MMO Reference: DCO/2022/00007
Planning Inspectorate Reference: EN010125
Identification Number: 20050160

Planning Act 2008, RWE Renewables UK Dogger Bank South (West) Ltd and RWE Renewables UK Dogger Bank South (East) Ltd Proposed Dogger Bank South Offshore Wind Farms Order

Deadline 9 Submission

Figure: 2.1	Drawing No:	
Co-ordinate system: WGS 1984 UTM Zone 30N	Page Size: A3	Scale: 1:850,000
Project:  Dogger Bank South Offshore Wind Farms	Report:

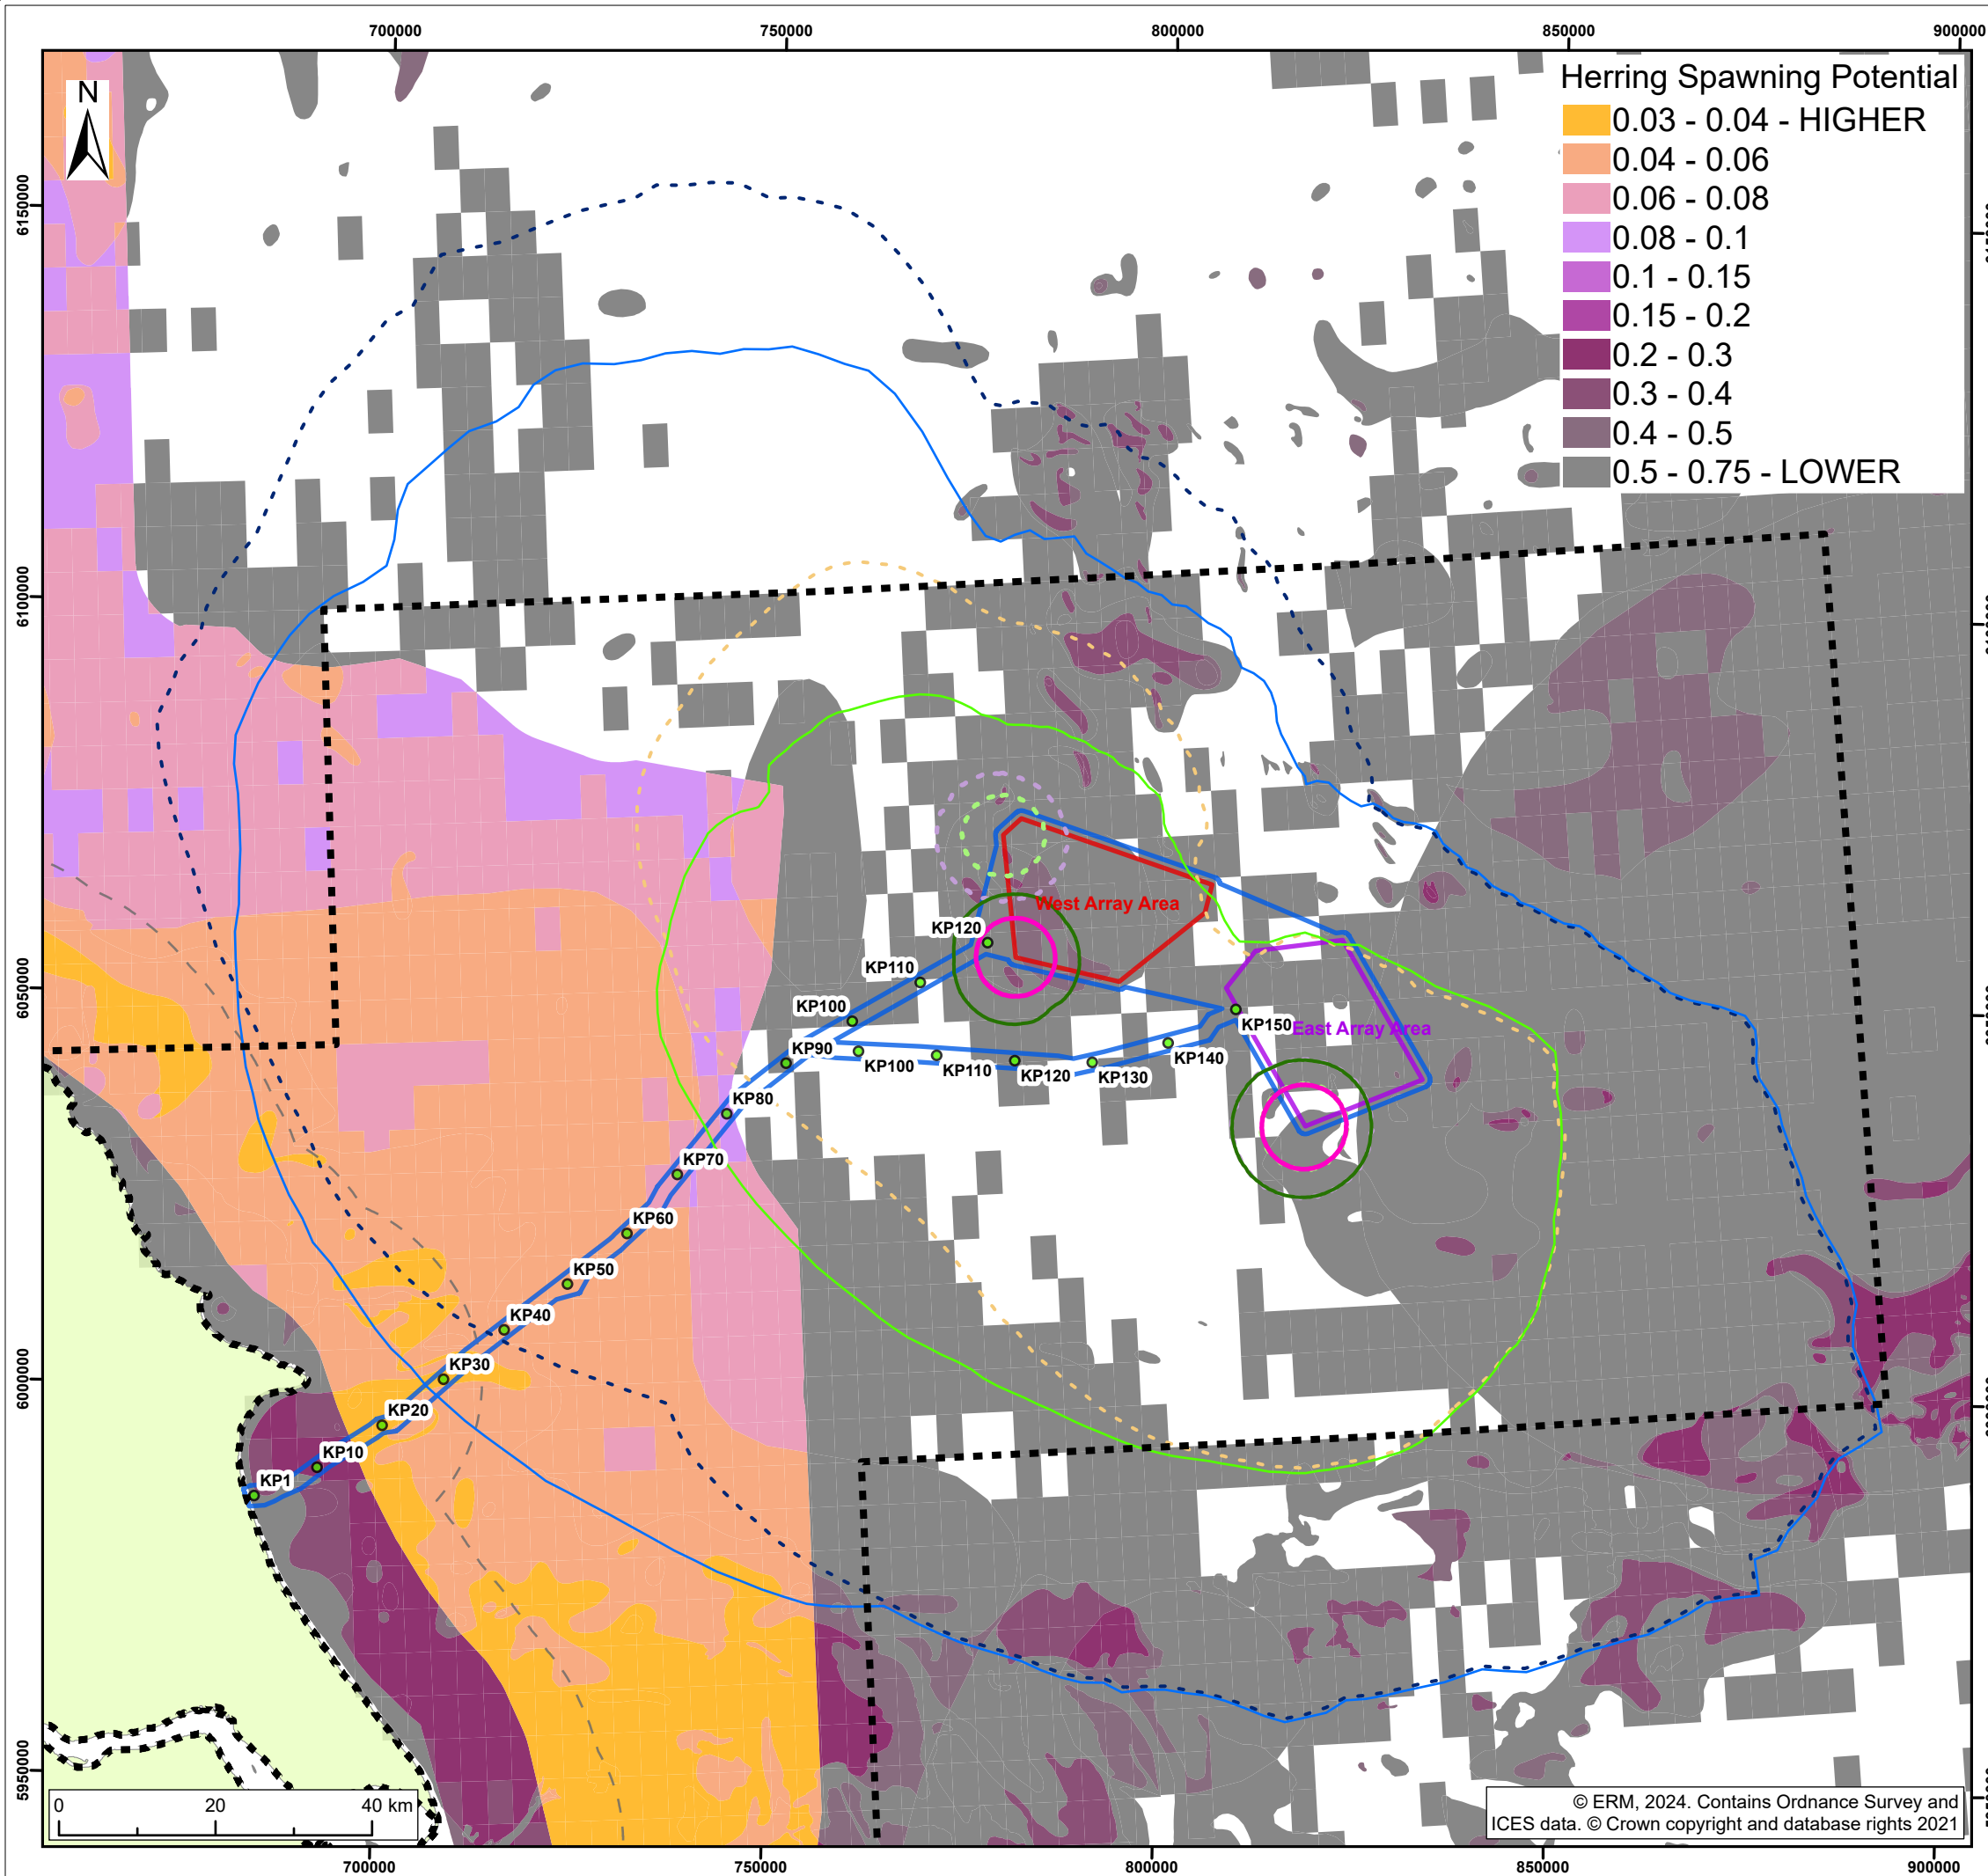
1.2.5 As per Figure 2.1 in REP5-042 (Modelling of underwater noise associated with alternative piling locations to inform potential impacts on Atlantic herring spawning grounds) this shows the worst case scenario with unmitigated piles. Figure 2.2 showed the 'Extent of preferred and marginal potential spawning habitat for Atlantic herring in the vicinity of the Dogger Bank South Offshore Windfarms overlaid with contours associated with revised and original monopiling locations'. The Noise Restriction Boundary line does not sit along the border of the preferred and marginal potential spawning habitat. The use of the terms 'preferred' and 'marginal' only refers to the types of sediment that herring spawning on (e.g. gravel & sandy gravel = preferred, gravelly sand = marginal). To be clear, the maps are 'heat' maps comprised of several layers of data including IHLS data and sediment (PSA data). Each data layer is associated with a scoring method, and when the scores of each data layer are combined, an overall 'confidence' score can be given. This gives some areas higher or lower scores, which broadly equate to the different 'heat' colours of the map. So, the heat maps show high (red) confidence in spawning near Flamborough Head, and high to medium confidence (peach) for much of the offshore area, with small patches of low (blue) confidence further out.

The Herring Spawning plan shows the Herring Spawning Noise Restriction Boundary along the border the habitat identified within Figure 2.2. Effectively the Applicant has drawn a boundary when there is no evidence linking this boundary to the impact pathway for UWN from piling.

1.2.6 Our main concern is that the Applicant **cannot** draw a physical boundary on the unmitigated noise impact.

1.2.9 As the MMO is not content with the proposed boundary then the MMO is not content with the condition. The MMO has proposed an alternative condition below linking to worst case scenario figure rather than the herring spawning plan:
